Our ref: DOC19/779746
Senders ref: SSD 8194

Subject: Dendrobium Mine Extension Project – Review of EIS – SSD 8194

ATTACHMENT A: Environment, Energy & Science (EES) assessment summary for Dendrobium Mine Extension Project (SSD 8194)

ATTACHMENT B - Environment, Energy & Science (EES) - Biodiversity and Conservation Division detailed comments for Dendrobium Mine Extension Project (SSD 8194)

Chart A6 Den 103 - Shallow Groundwater Level and Moisture Content

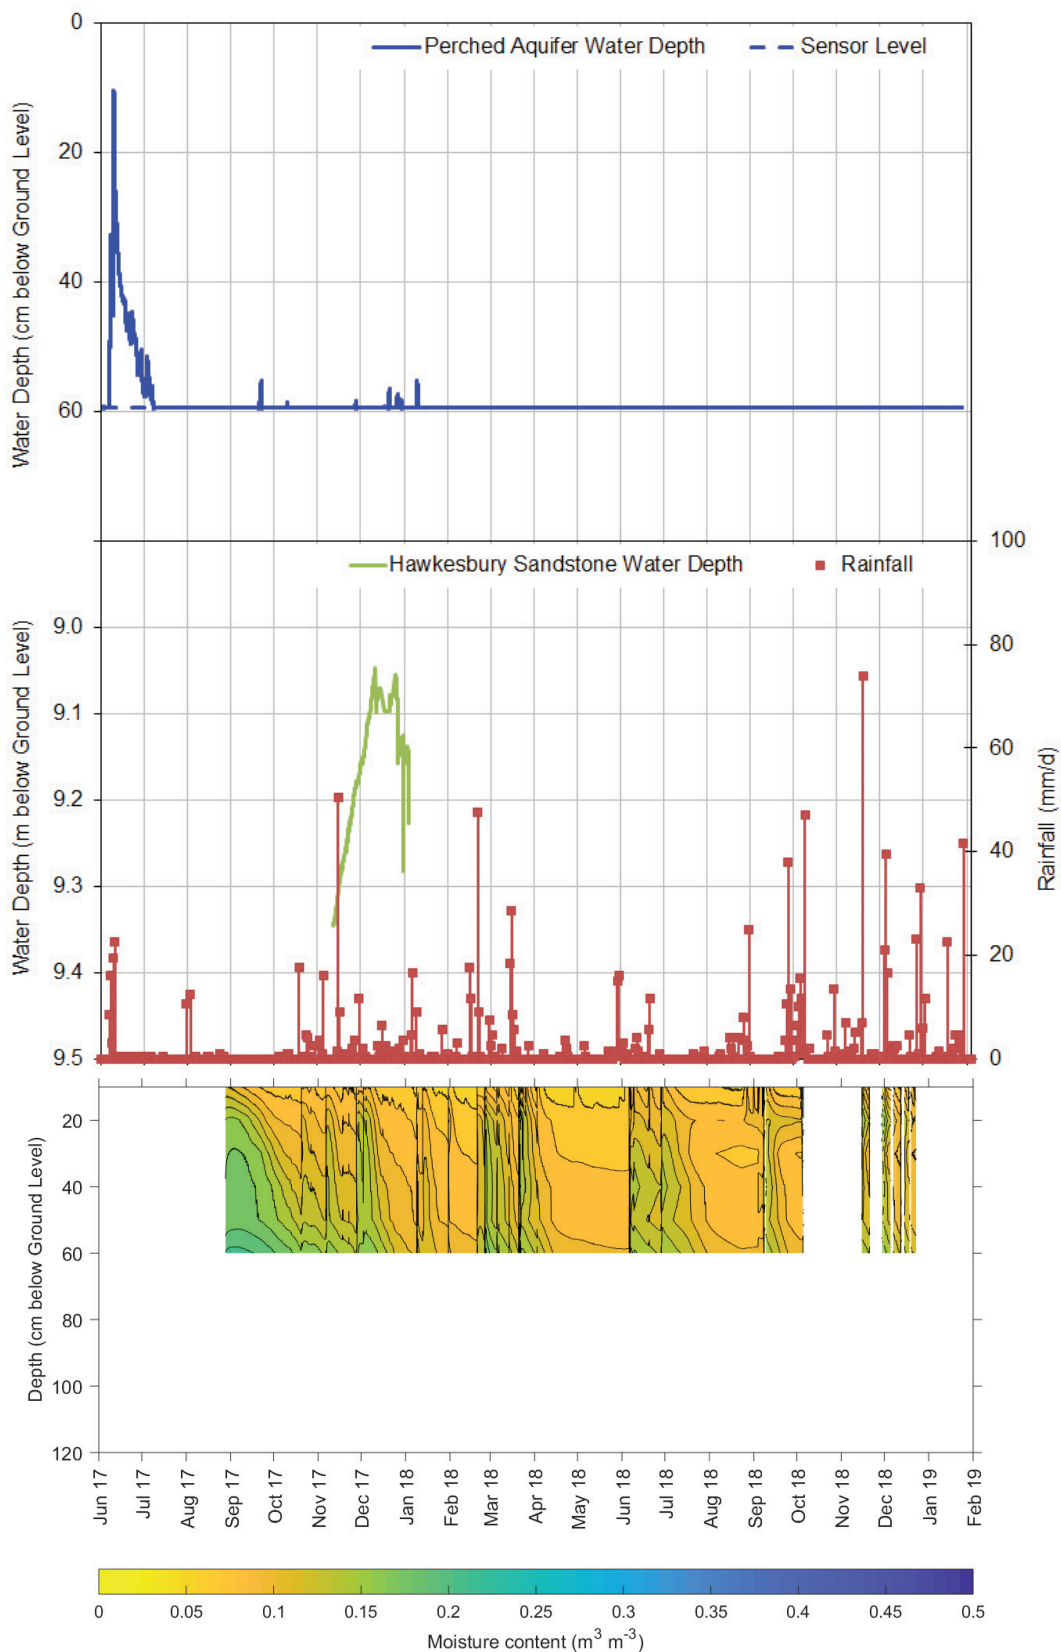
- The data that is used to characterise the shallow groundwater in the majority of monitored upland swamps in Areas 5 and 6 does not show a response in the groundwater level or soil moisture from a significant rainfall event. This raises doubt about the quality of data used to inform the upland swamp impact assessment and future monitoring of impacts from mining.

4	<i>Issue</i>	Peer review of upland swamp shallow groundwater monitoring data
	<i>Extent and Timing</i>	As soon as practicable
	<i>Recommended action</i>	<ul style="list-style-type: none"> We request access to all raw swamp monitoring data to review.
